**WELWYN HATFIELD BOROUGH COUNCIL – DEVELOPMENT MANAGEMENT**  
**DELEGATED REPORT**

**APPLICATION No:** W6/2015/0249/EM

**SITE ADDRESS:** 181 Parkway

**DESCRIPTION OF DEVELOPMENT:** Erection of single storey side extension. Part replacement of external outbuildings, installation of downstairs WC and widen the existing garage

DRAWING
PROPOSED ELEVATIONS

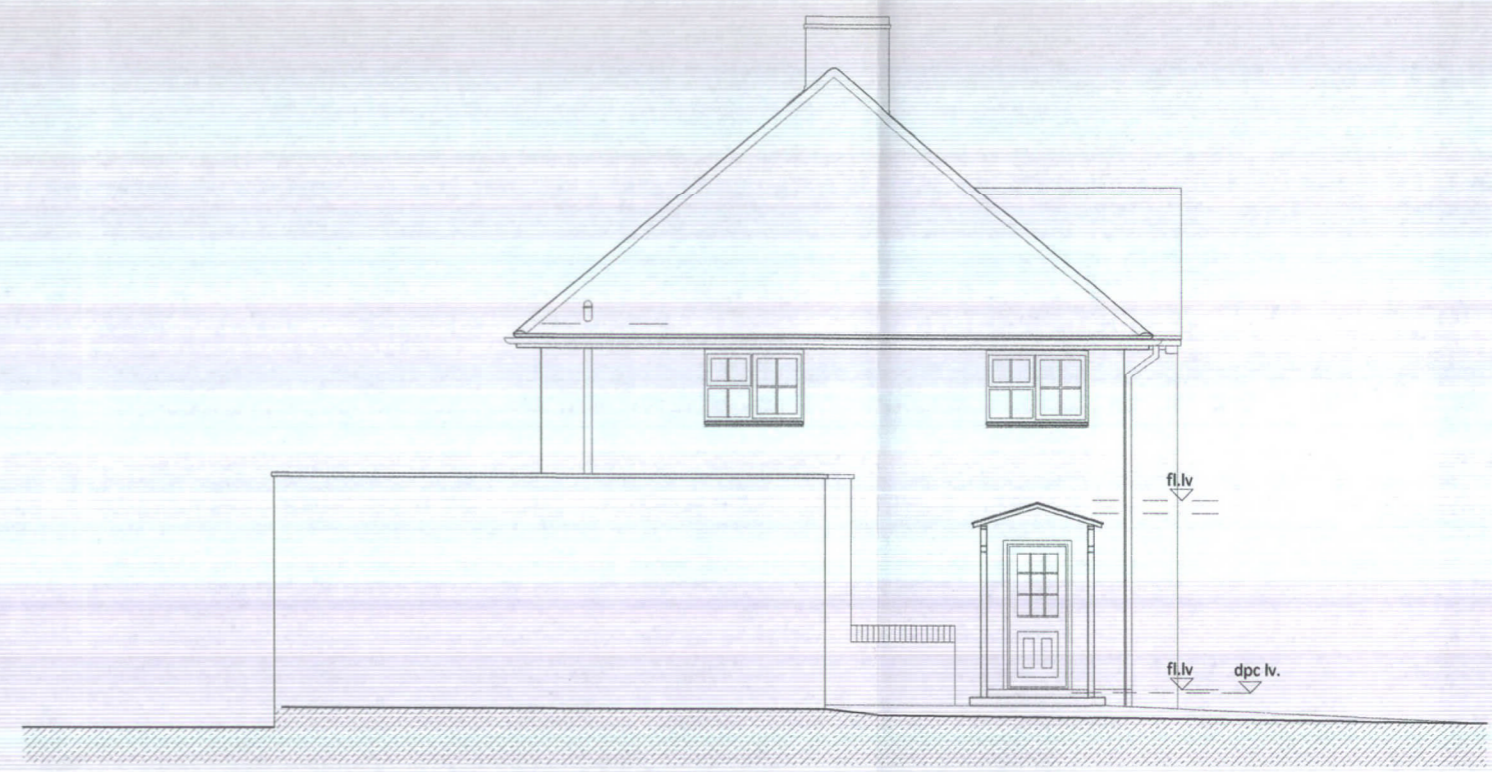
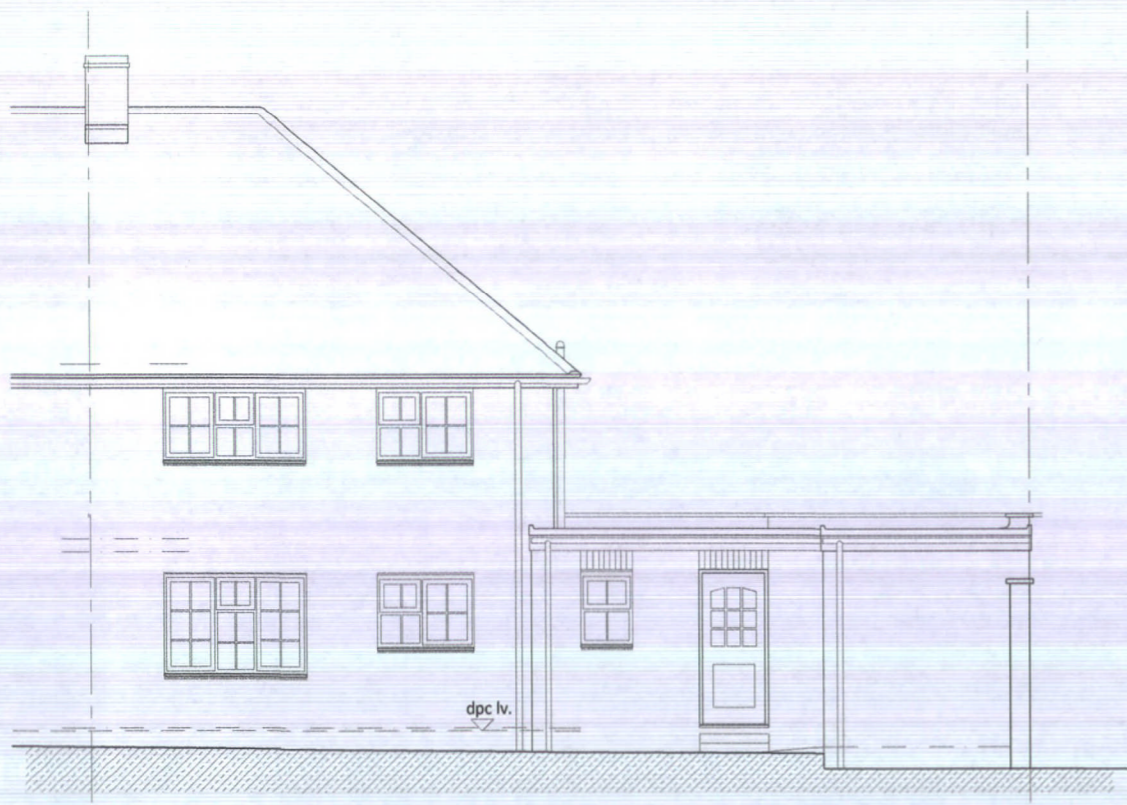
Whilst the proposal would increase the mass, scale and bulk to the host property its impact would be limited given it would retain its existing (maximum) height, depth along the northern boundary. Furthermore the proposal would retain the existing flat roof design, garage door and brick facade appearance to the front, and would have a modest proposed projection to the rear. In this context, and taking into consideration that the proposal would have no discernible visual presence within the streetscene, it is considered a subordinate addition to the host property in terms of its added bulk, mass and scale.

The fenestration change; to the front proposes a replacement door and new single window; and the changes to the rear also propose a replacement door and new single window. Although the proposed changes would differ from the existing fenestration, the proposal is considered acceptably sensitive to the existing fenestration in the property. Furthermore they would be Georgian in style in keeping with other doors and windows within the host property. Additionally the proposed bin store area to the front is considered an acceptable design.

7. EM03 - The brickwork, bonding, mortar and architectural detailing (including soffits, eaves, external pipe work and guttering) of the approved extension shall match that used in the existing dwelling, unless otherwise agreed in writing by the council.

DRAWING
 PROPOSED PLANS

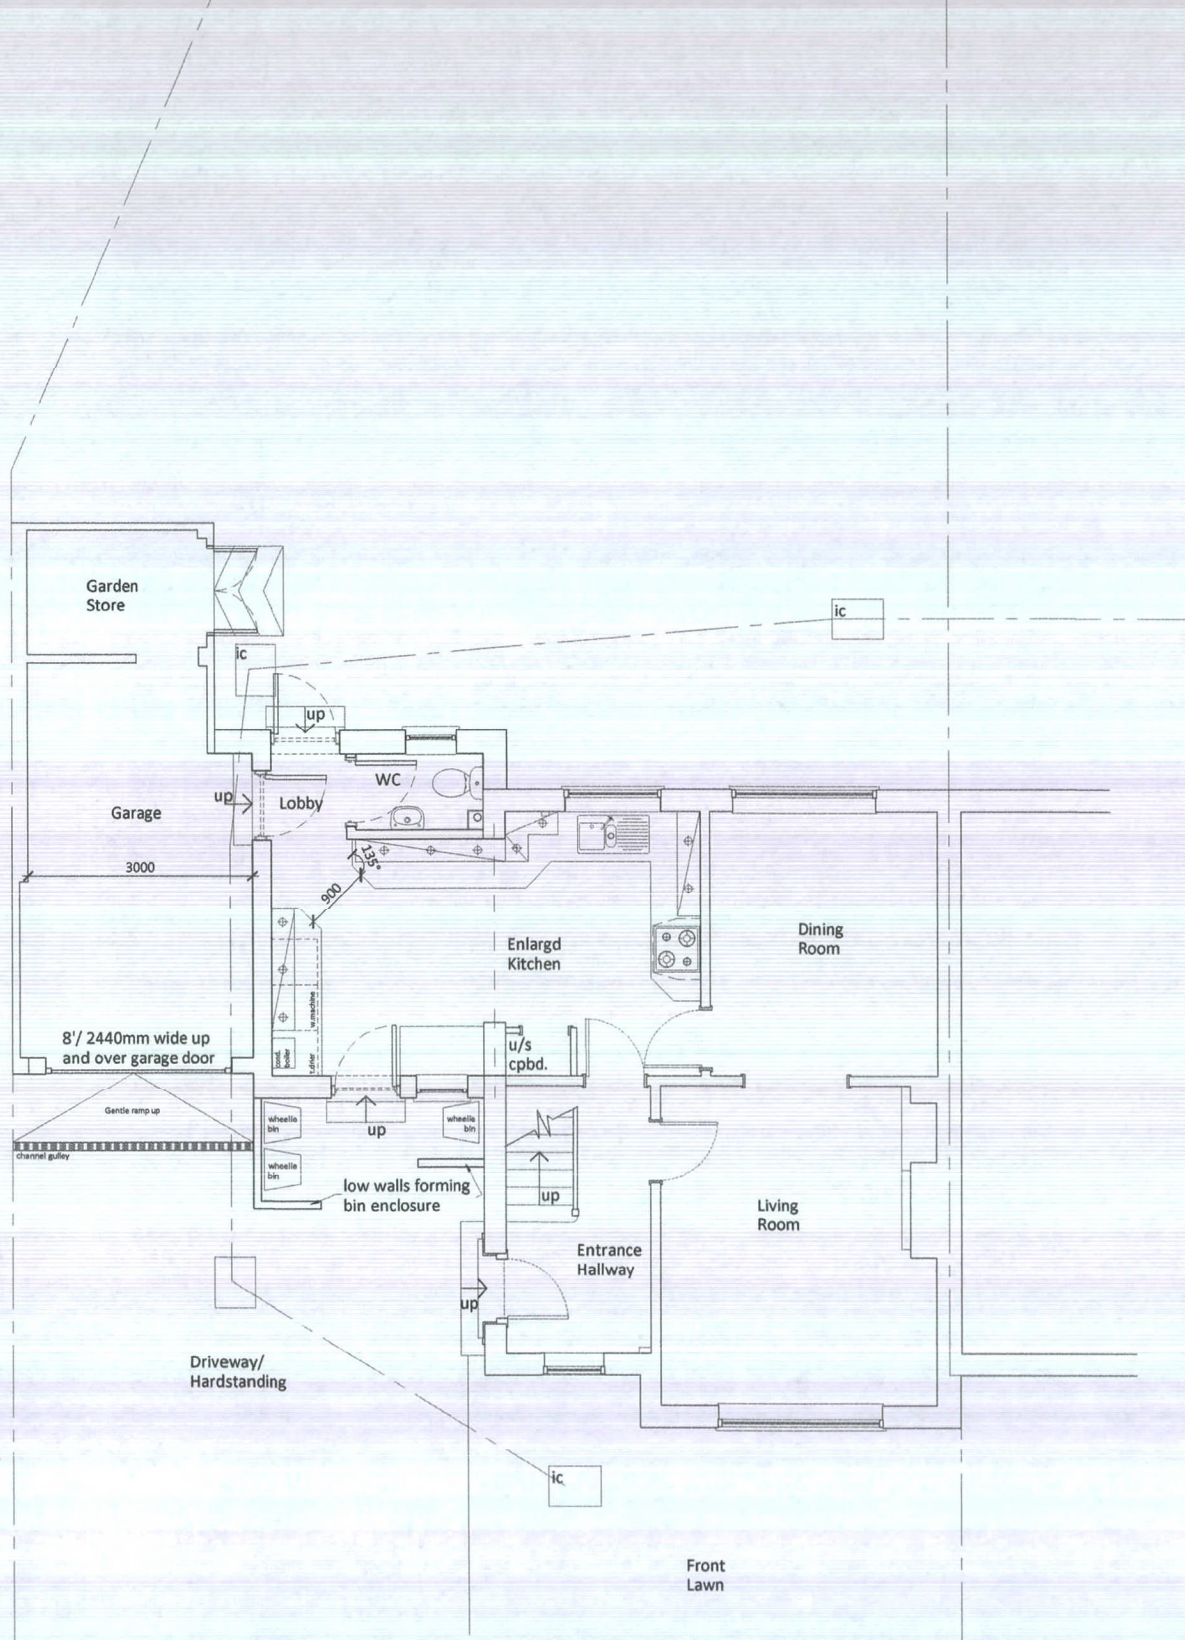
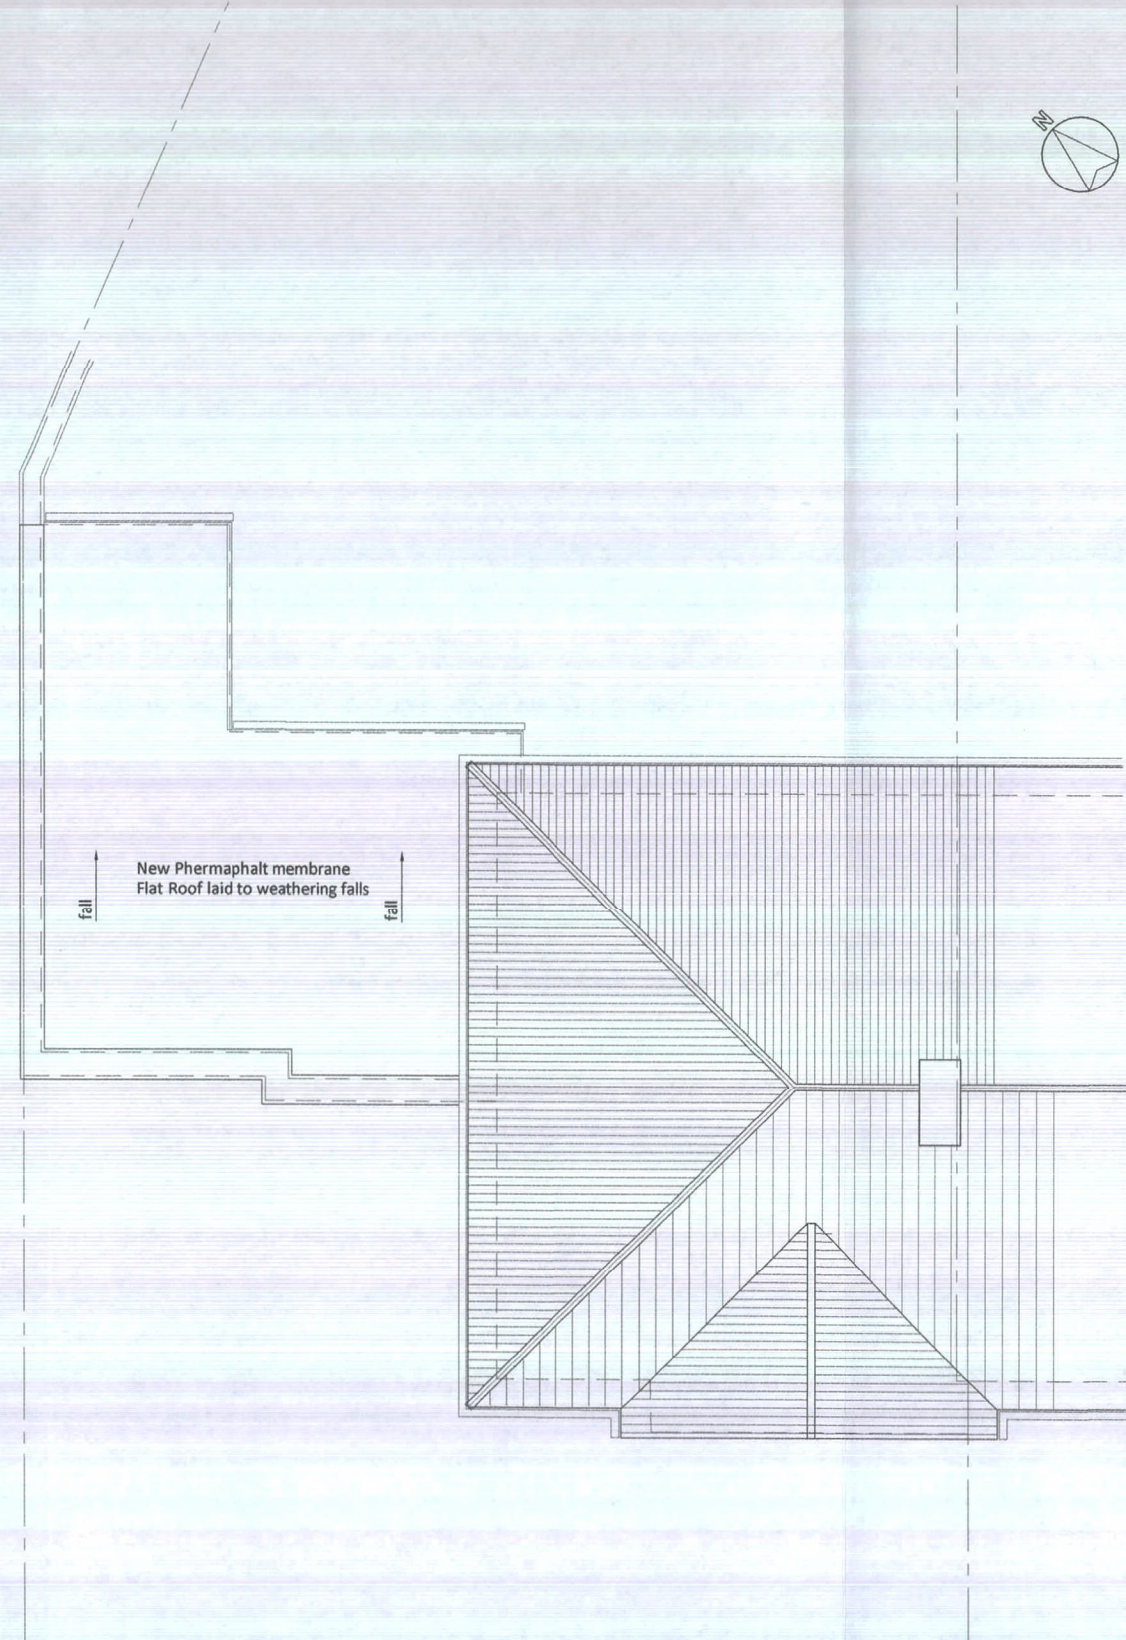
The applicant proposes the erection of a single storey side extension, and part replacement of the existing outbuildings. The proposal would widen the existing garage, retain the existing side element, and part extend and replace the existing outbuildings with this section of the extension in filling the gap beyond the existing brick façade, and between the existing garage / outbuildings, and flank wall.
